**KIRKLEES METROPOLITAN COUNCIL
INVESTMENT & REGENERATION SERVICE**

**DELEGATED DECISION TO DETERMINE APPLICATIONS FOR
NON-MATERIAL AMENDMENTS**

Reference No: 2025/NM/93370/W

Description: Non material amendment to previous permission
2021/92062 for erection of 9 dwellings and associated
works

ISSUED TO:		PLANNING	
Project/Client:	Residential Development	Project No:	23-035
Land at Britannia Road	Golcar, HD3 4QB	Dwg No:	102
Scale:	A.S.	Rev:	C
Scale:	@A1	Drawn By:	RJ
Scale:	02/01/24	Date:	
Scale:	02/01/24	Checked By:	SC
Scale:		Date:

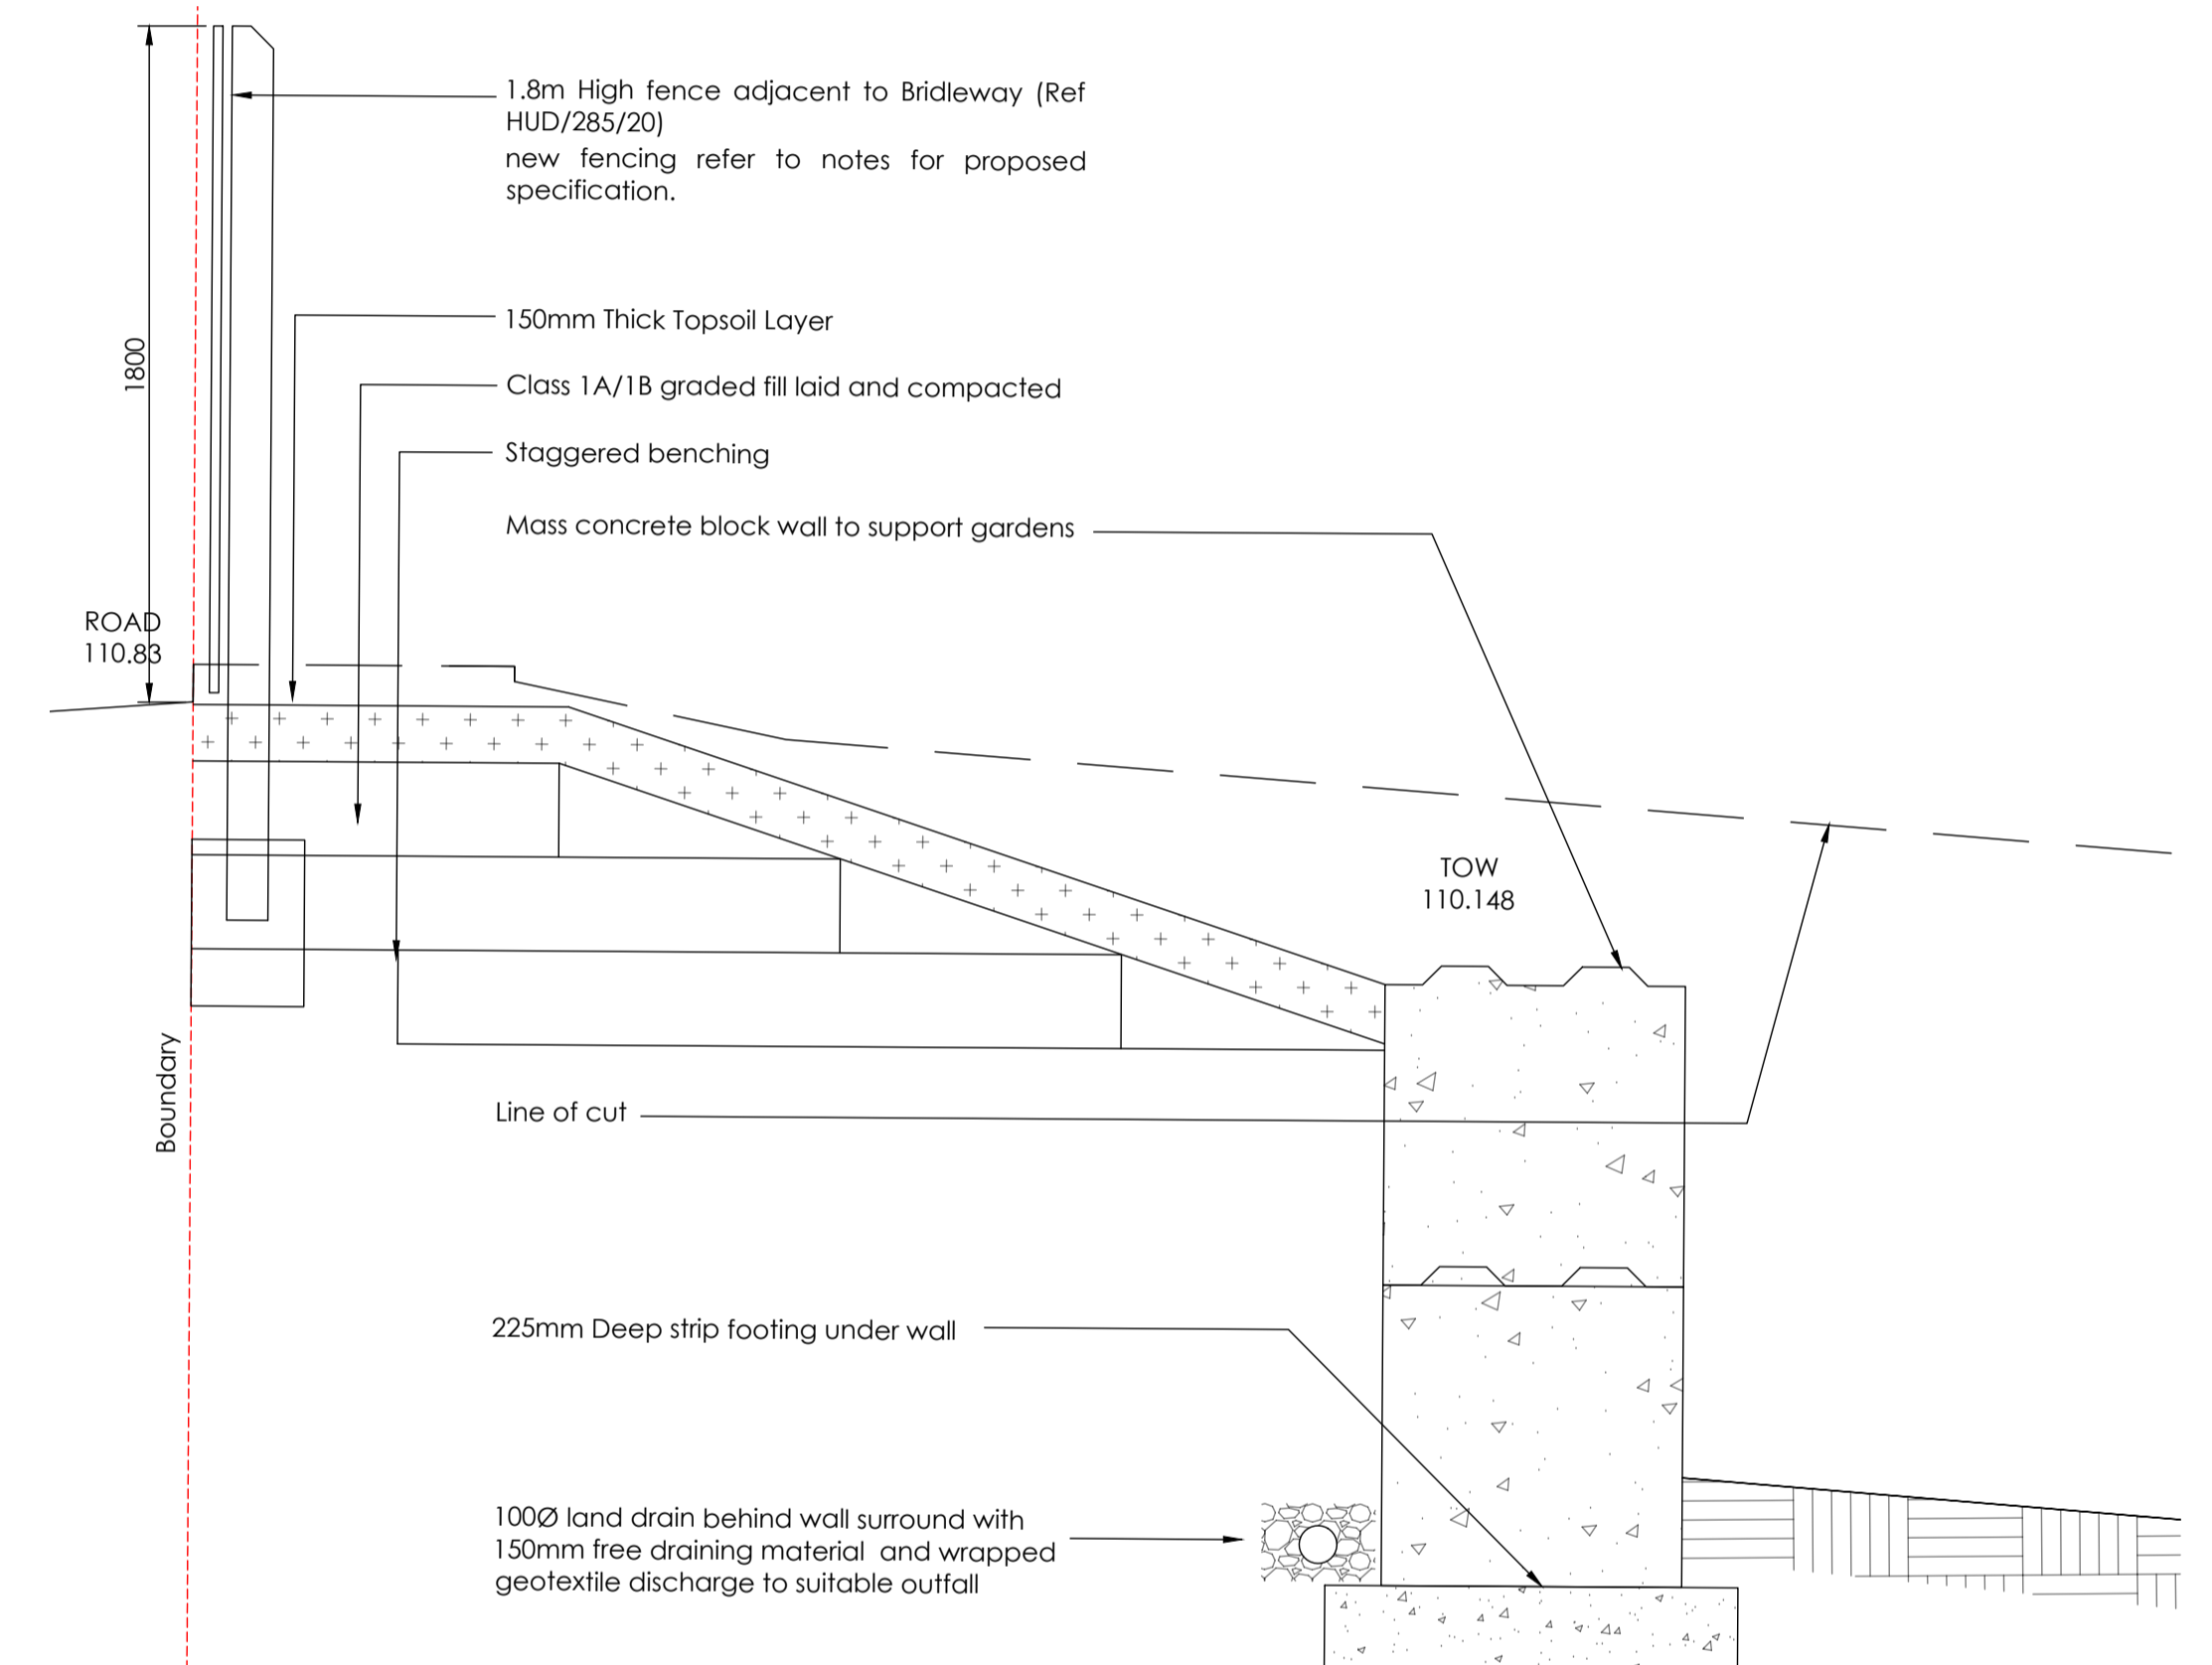
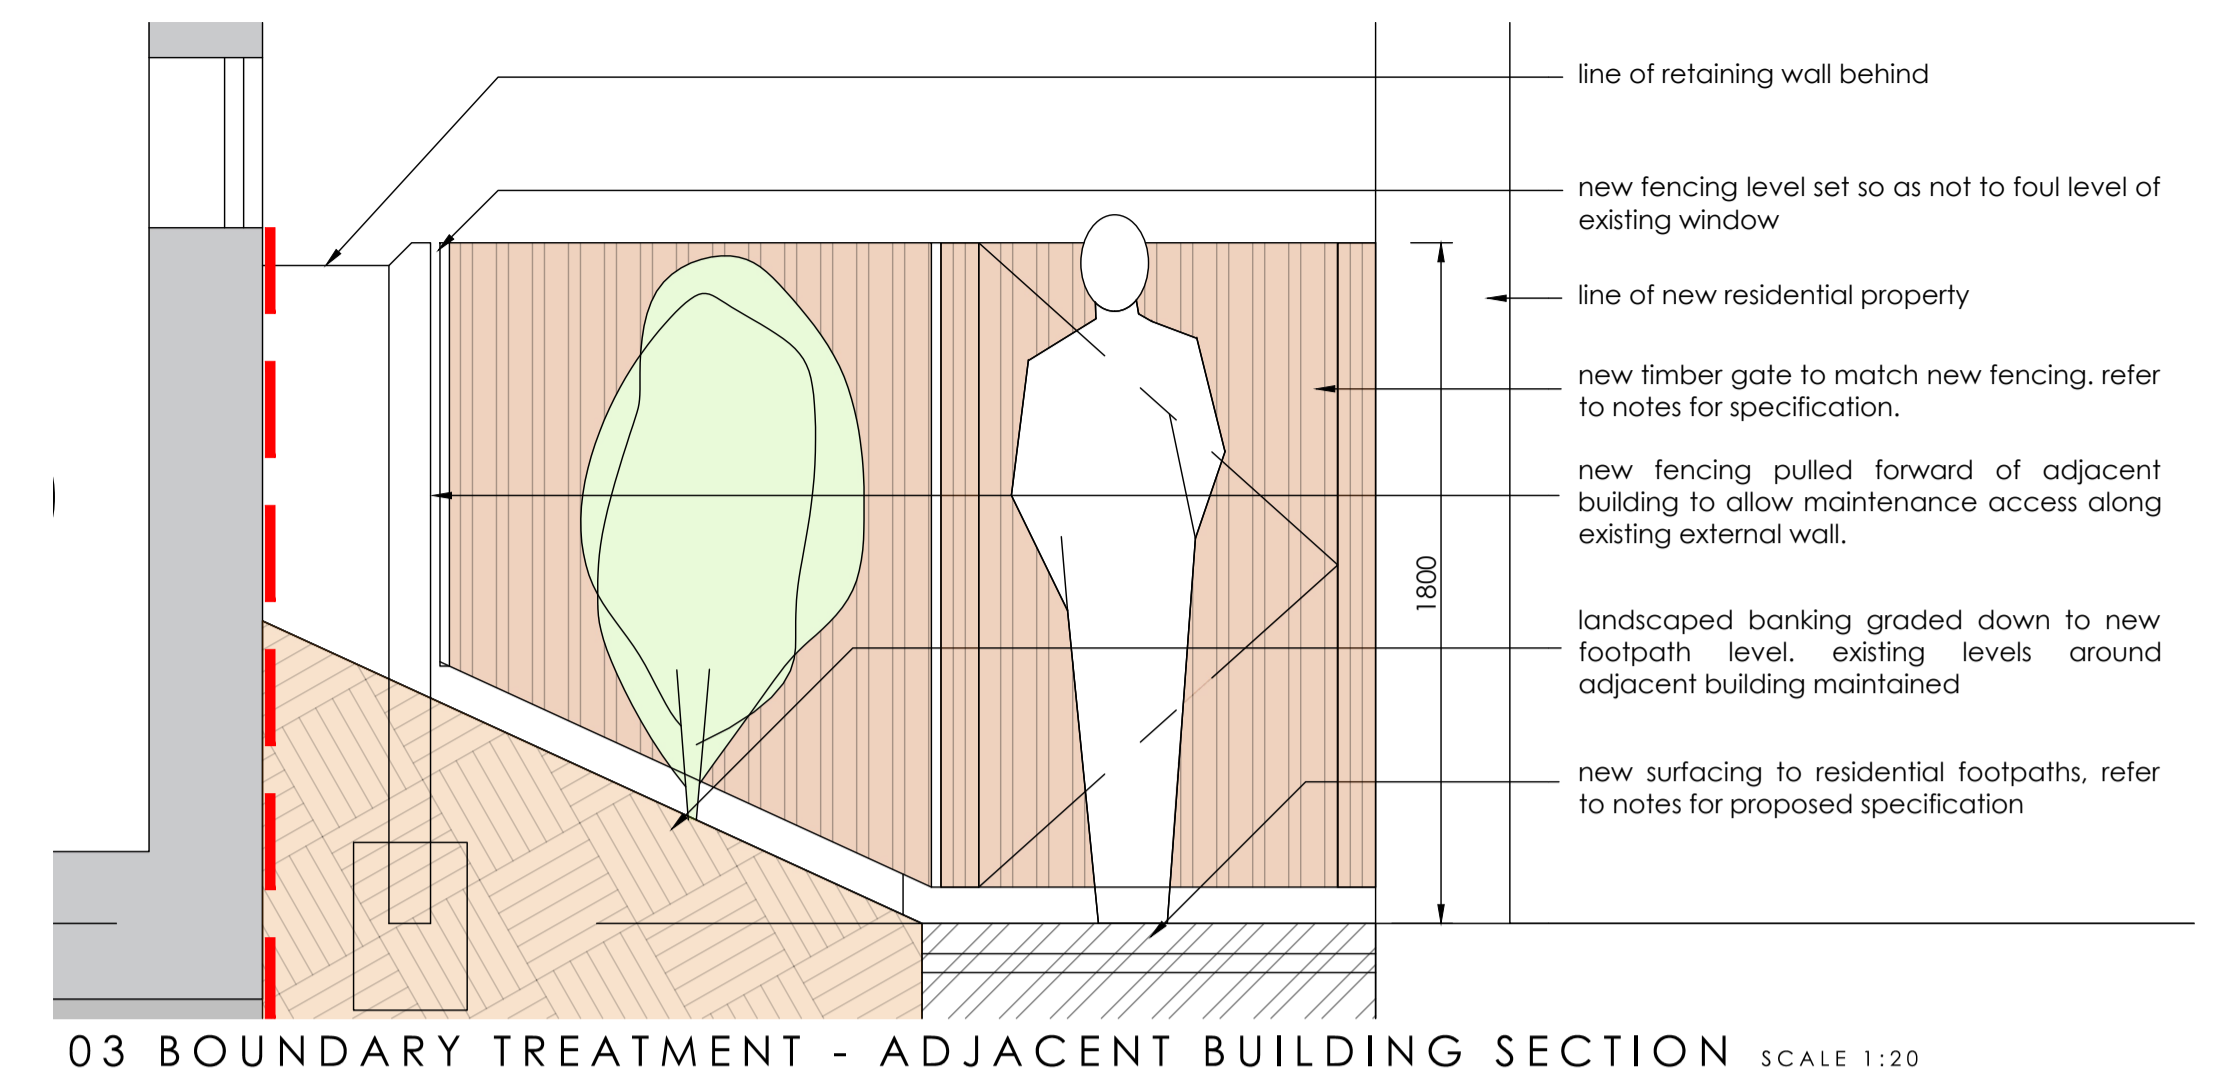
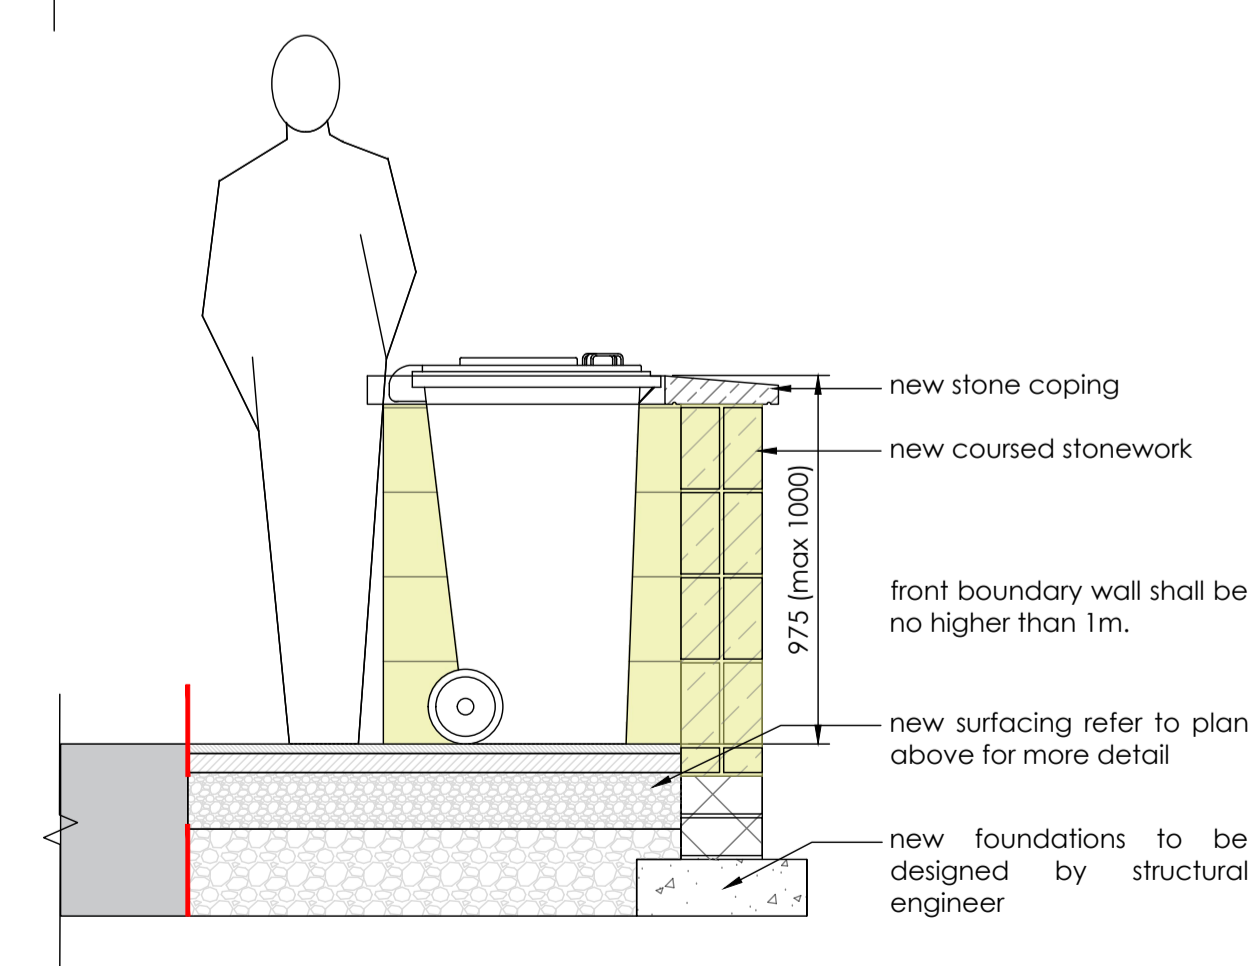
- Modifications to the previously approved retaining and boundary walls to accurately reflect the correct site levels.
- Revision of boundary walling agreed under AIP approval.

Plans have also been submitted which show details of boundary treatments. These details are required to be discharged under Condition 14 of previous planning permission 2021/92062.

14. Boundary treatment and treatment of retaining walls (i.e. facing materials) throughout the site shall be undertaken in accordance with hereby approved drawing nos. 100, Rev B, 101, Rev B and 102 Rev C, received 08/12/2025. The front boundary wall, adjacent to Britannia Road, shall not exceed 1.0m in height. The dwellings shall not be occupied until the works comprising the approved scheme have been completed and thereafter retained for the lifetime of the development.
